From: Simon Davis
Sent: 19 January 2018 12:32
To: 'Chris Moore'
Subject: AL/114/17/NMA 27A Belle Meade Close

PROPOSED ROOF PLAN

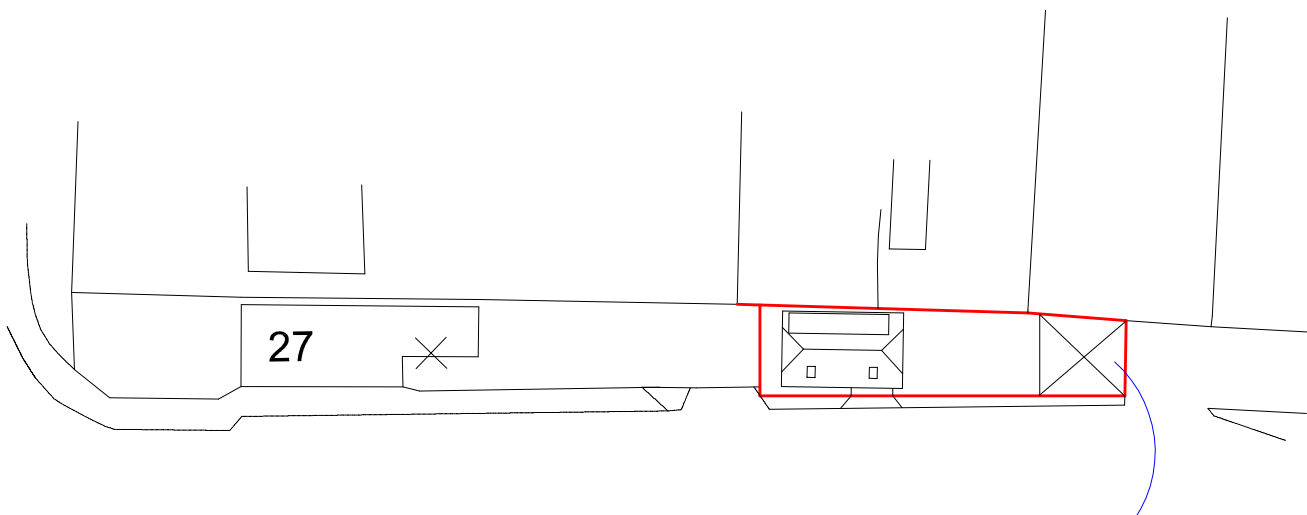
However, notwithstanding the above I have reservations about whether this can be considered as a NMA. I attach our latest internal NMA guidance. The proposal effectively creates a garage where there was not one previously (the approved plans are unclear as to whether there was to be a structure in this location or not). This would seem to materially alter the approved scheme. Furthermore even if there was a structure, then the increase in height of this is in excess of 0.3m.

PROPOSED ELEVATIONS

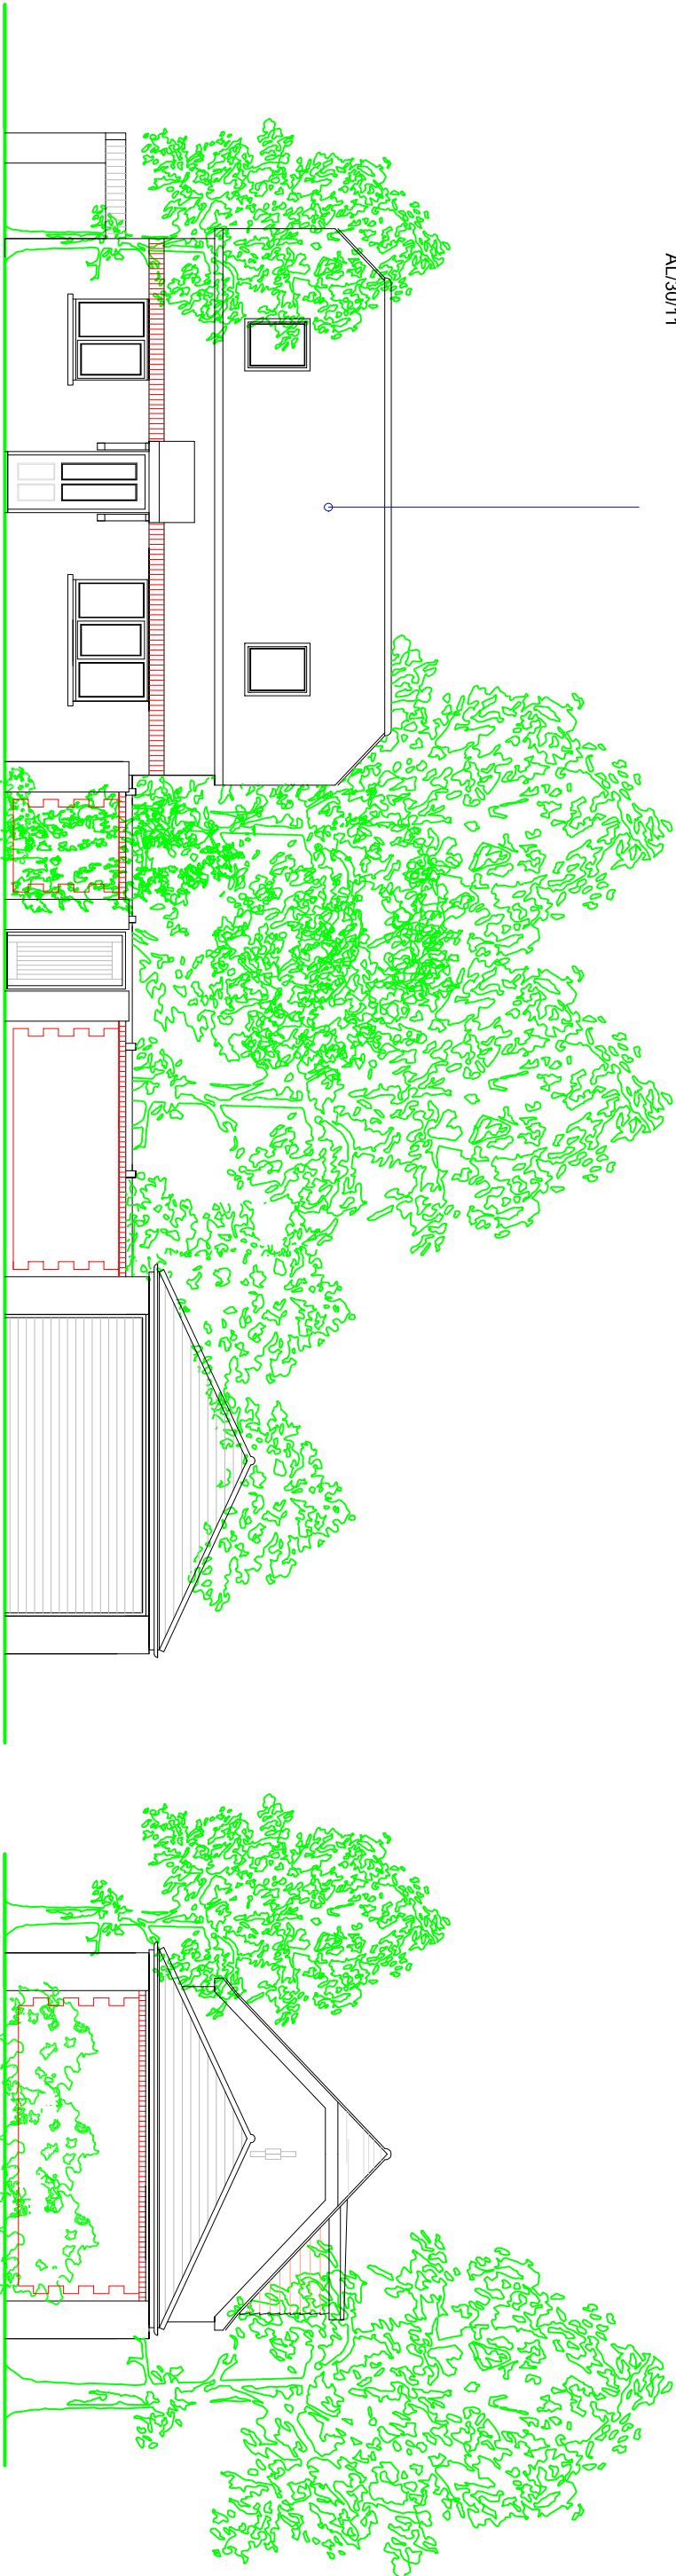
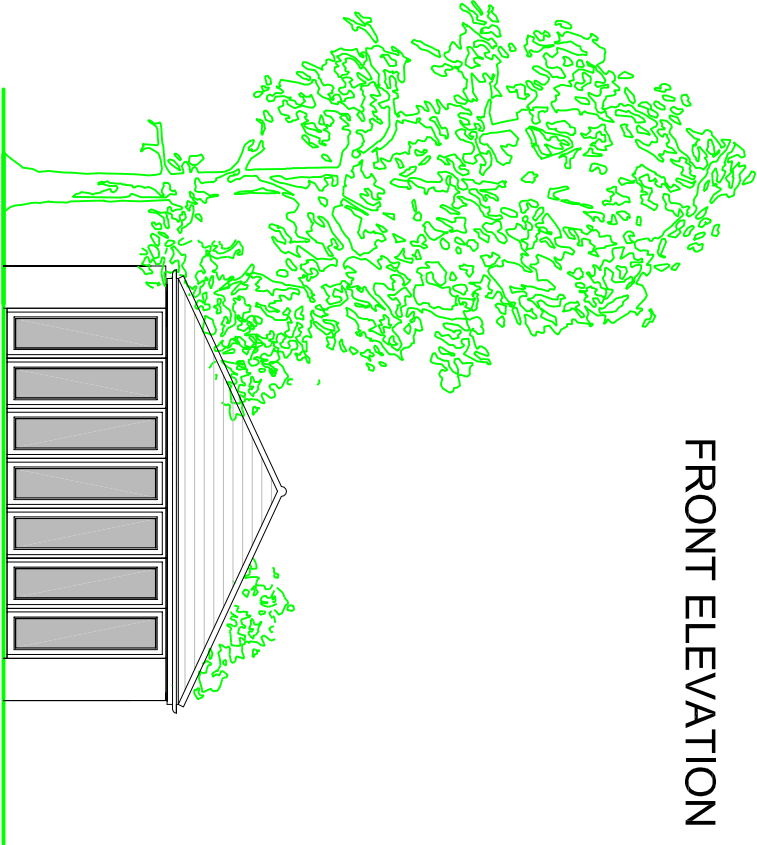
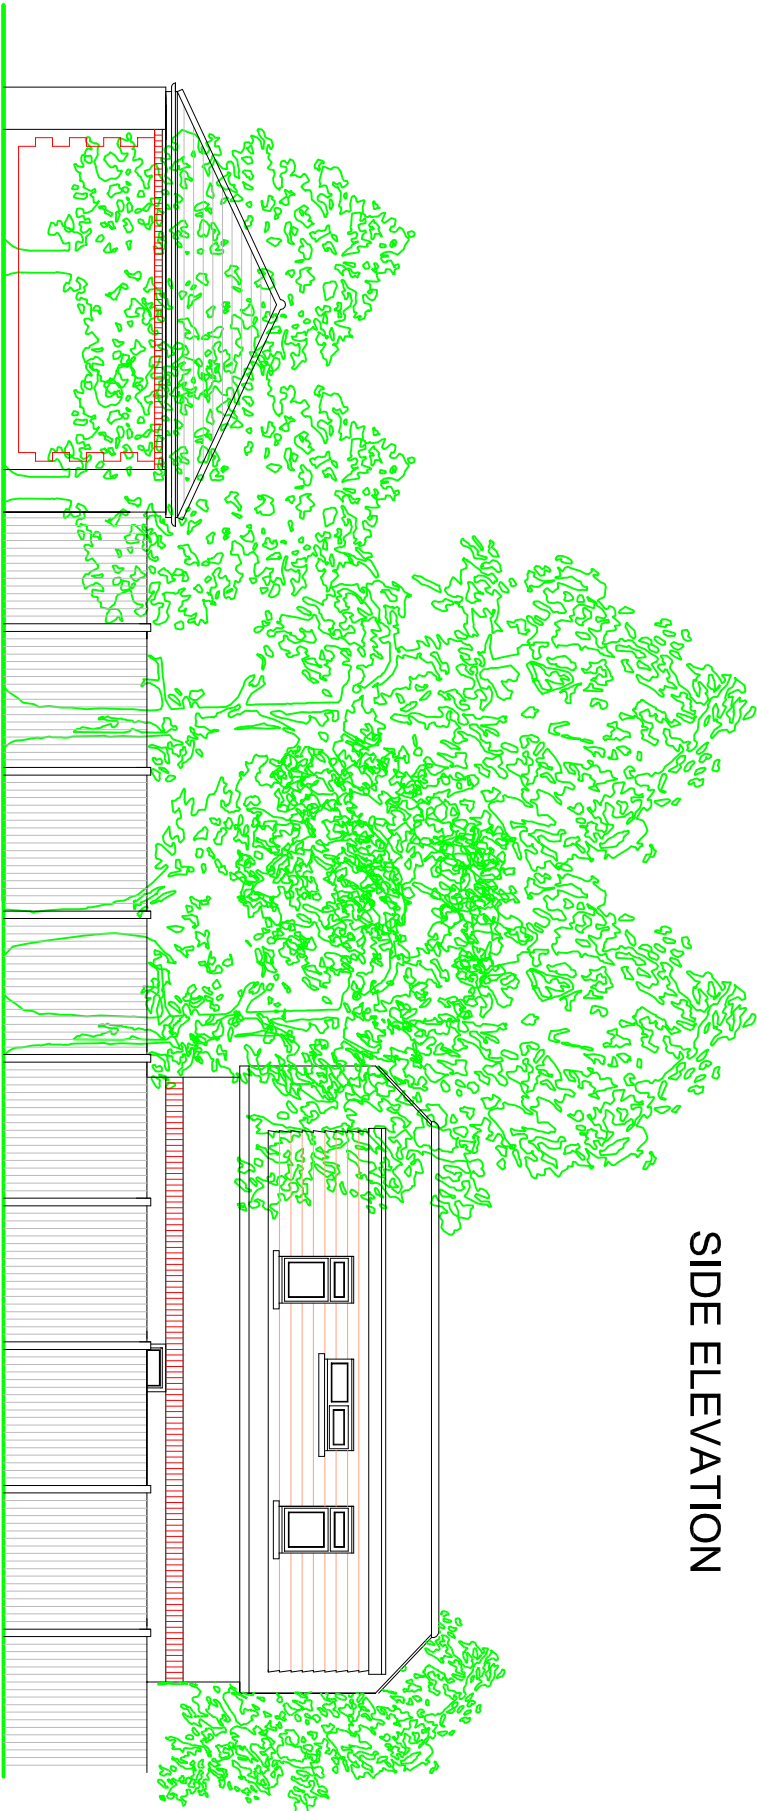
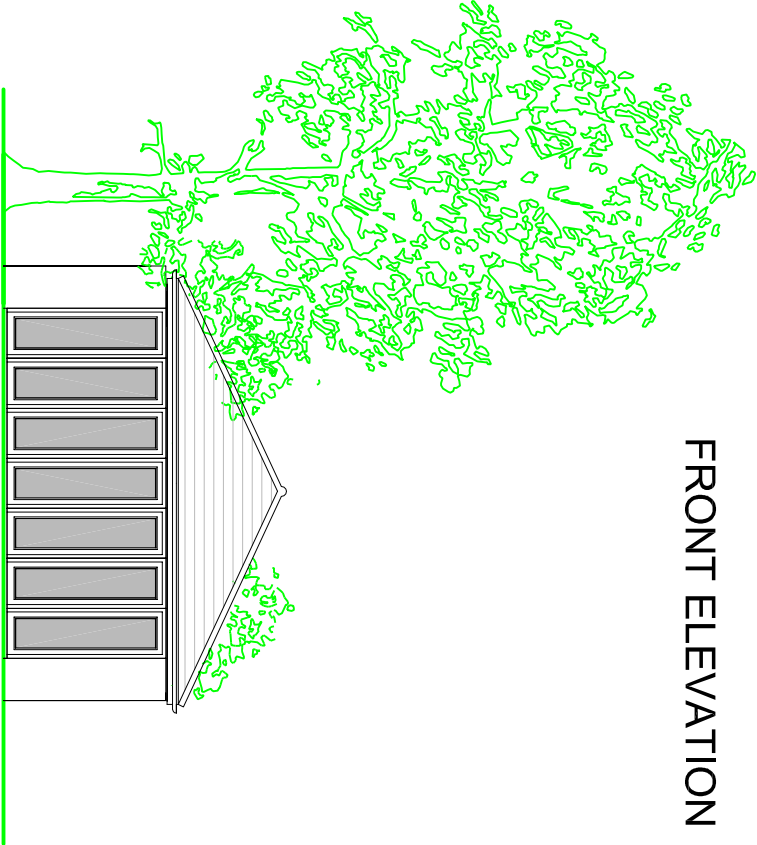
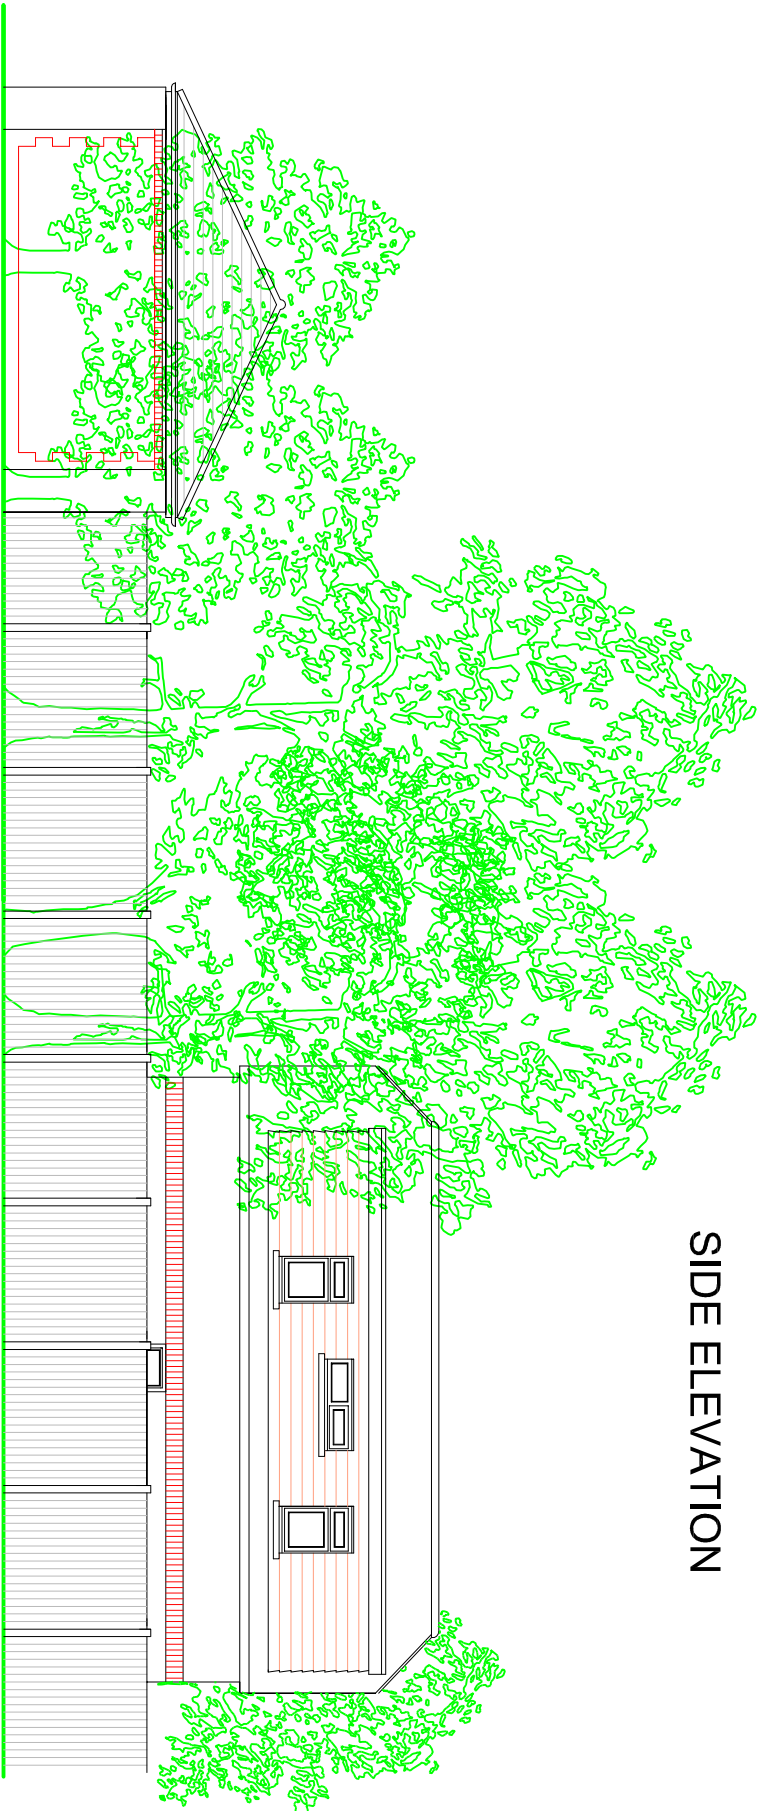
- * You say that the height of the boundary walls will increase. However, the submitted plans do not make it clear which boundaries are being increased and to what. The approved plans show a mix of 1.9m and 2.1m fences/walls. The submitted plans seem to concur with the measurements on the approved plans. Can you explain where this change relates to and what the increase is.
- * It is unclear what the infill wall relates to. Is this to either side of the new folding doors to the garage?
